From: Sue Howell
Sent: 15 January 2018 16:33
To: Planning.Responses
Cc: Anita Gardner
Subject: RE: Planning Consultation on: WA/75/17/PL

Comment from Greenspace

Registered: 31st October
 2017
Site Address: Land adjacent to Sunny Corner Copse Lane
 Walberton BN18 0QH
Grid Reference: 496503 106526
Description of Works: 9 No. dwellings with associated car parking, bin storage & landscaping & creation of new access road from existing access onto West Walberton Lane. This application is a Departure from the Development Plan.

Drawing title: Proposed Site Layout

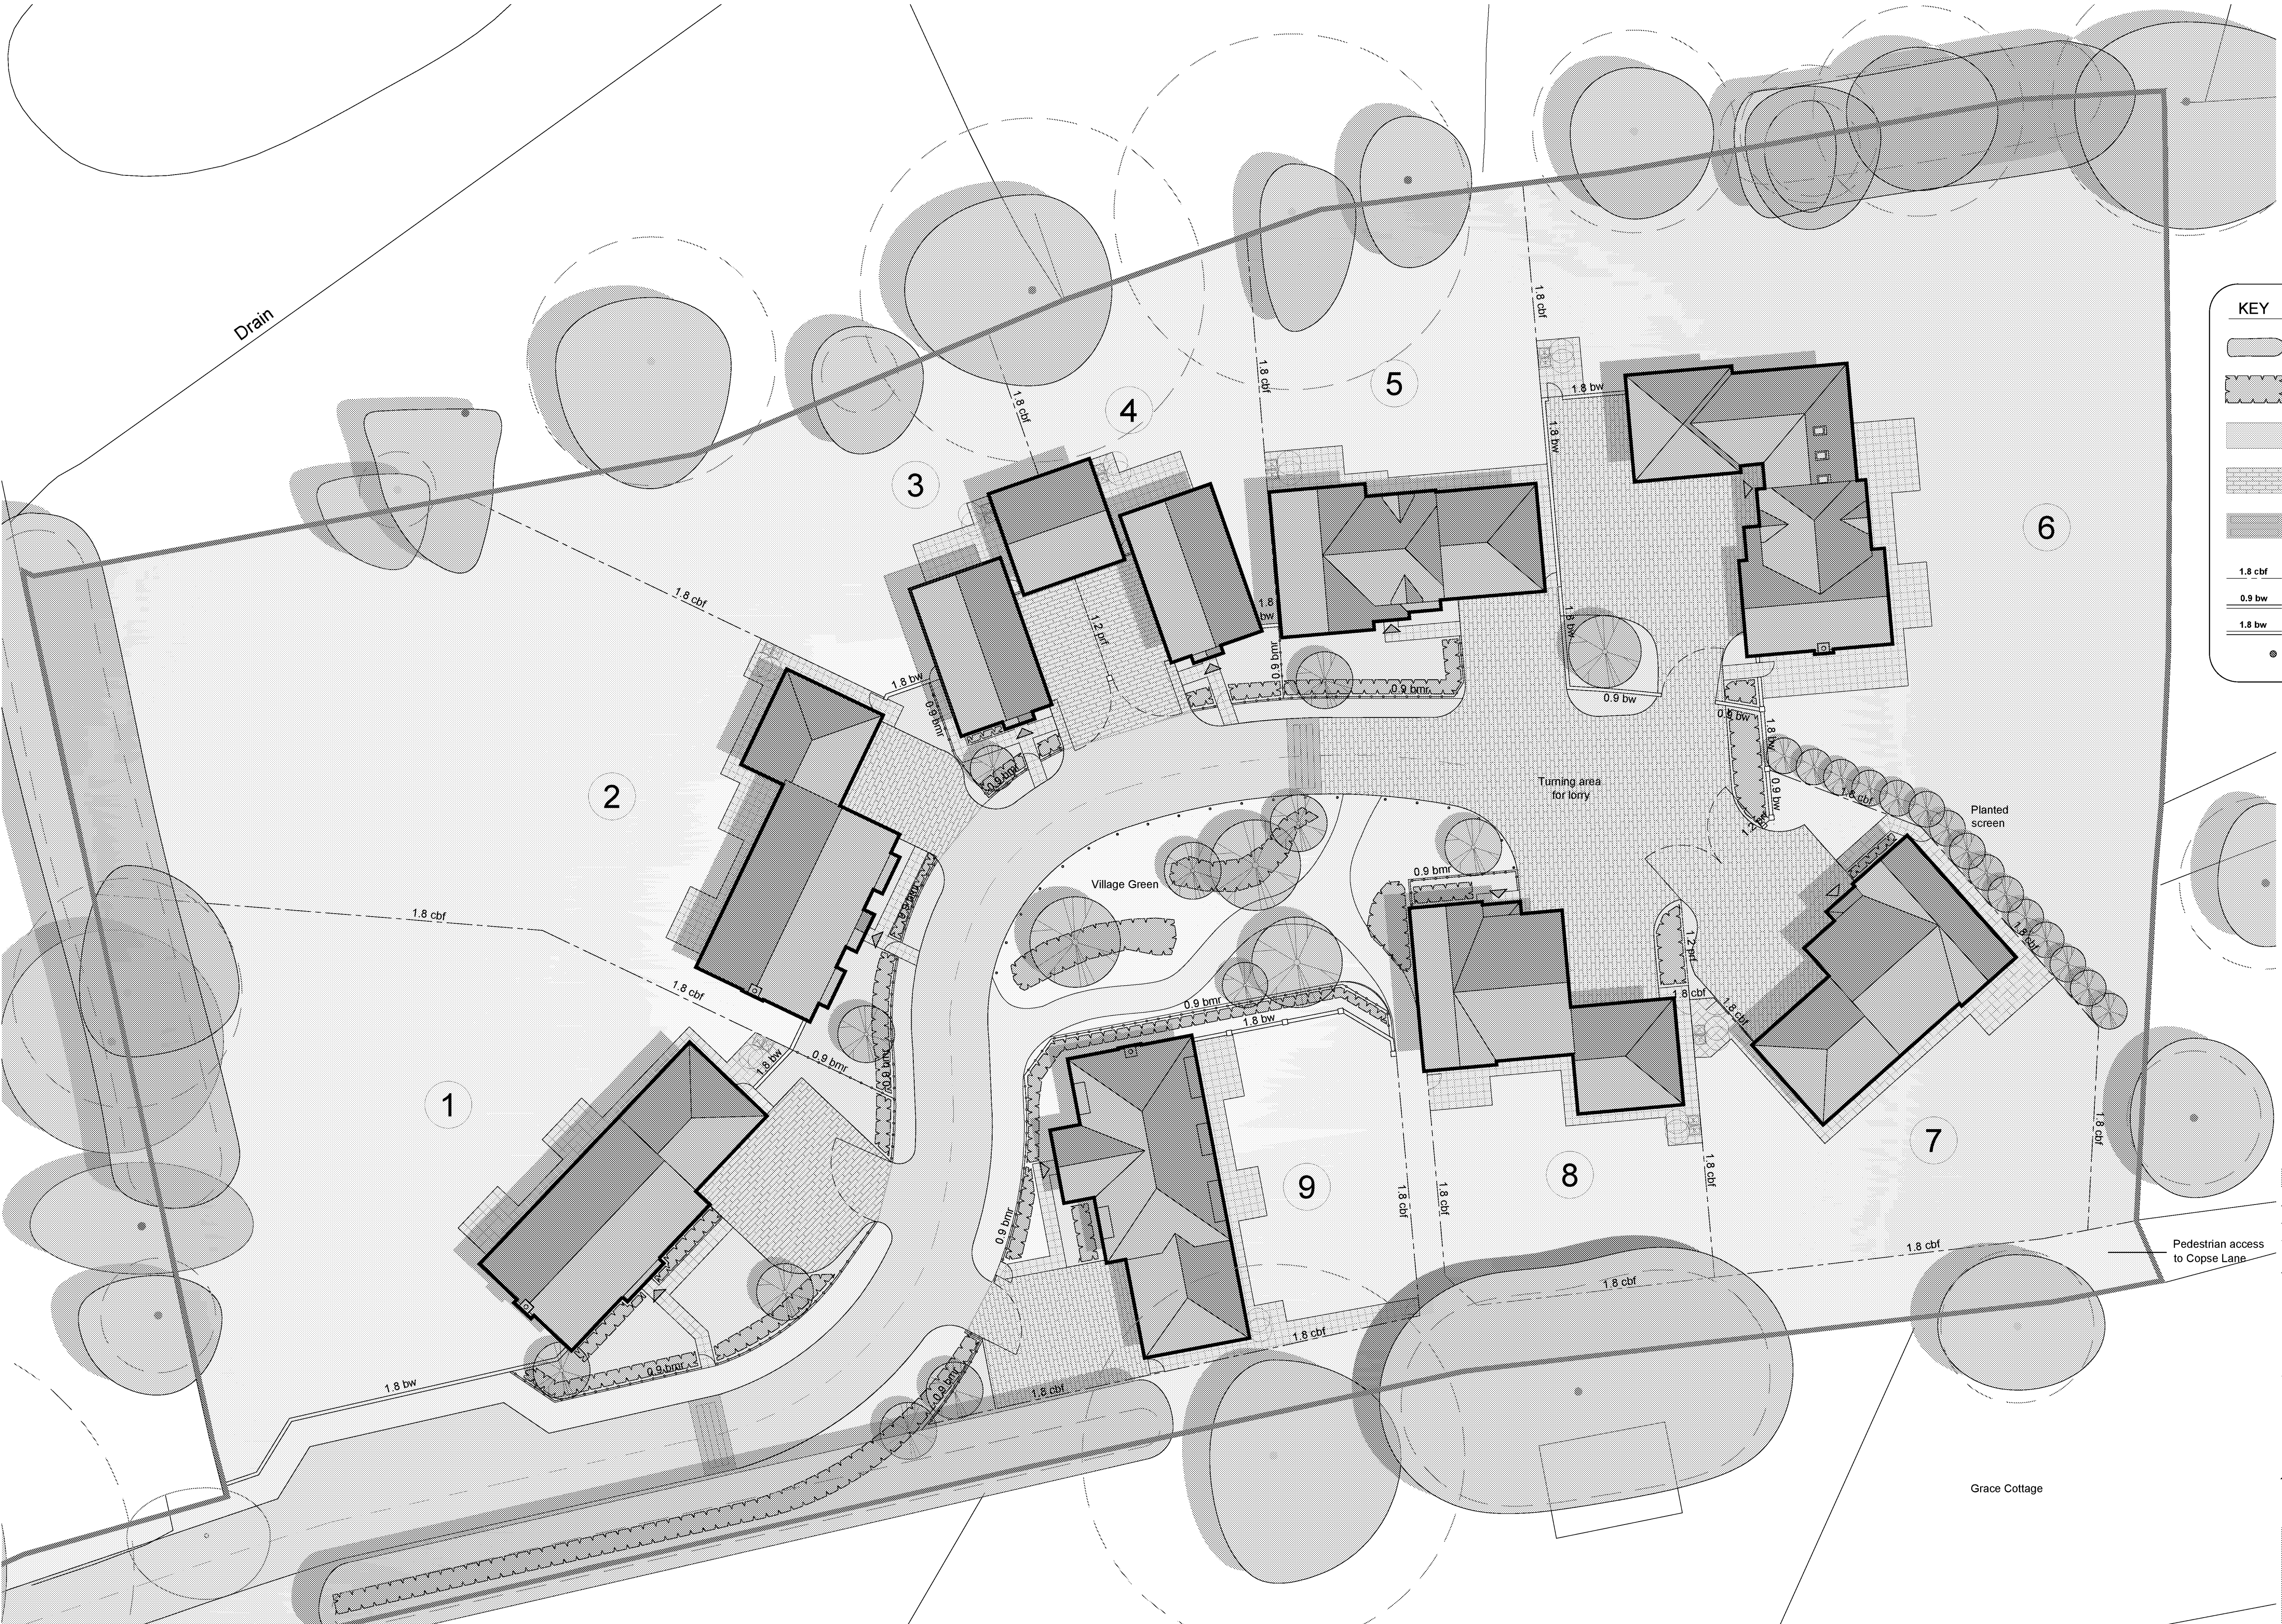
The proposals put forward in this application have included consideration of its siting within the existing landscape. Existing landscape features such as existing screening trees and hedgerows have been considered and indicated within the layout proposals. A further detailed landscape scheme will need to be proposed that will maximise the biodiversity of the site in its semi-rural setting with the inclusion of mixed ornamental and native species for the retention of a variety of habitats. The landscape proposals will need to be shown in plan from detailing species choice, planting densities and size at time of planting. This will need to include mitigation planting for any removed vegetation and additional planting would be required to provide screening and to soften what is presently a green area. This is particularly required in order to encourage the proposals to fit within the setting.

The existing vegetation to the surrounds of the proposals is established with some significant and aesthetically valuable trees, these areas must be protected and retained. The submitted Arboricultural Impact Assessment 2017 indicates the tree protection measures to be taken. Before construction, this tree protection scheme must be in place for all retained trees including trees whose root protection areas fall within the construction zone. This should be in accordance with BS 5837:20012 'Trees in relation to construction' Any tree removal must be in consultation with Arun District Councils Tree Officer.

I would recommend no landscape objection to the proposals subject to the submission and implementation of details above.
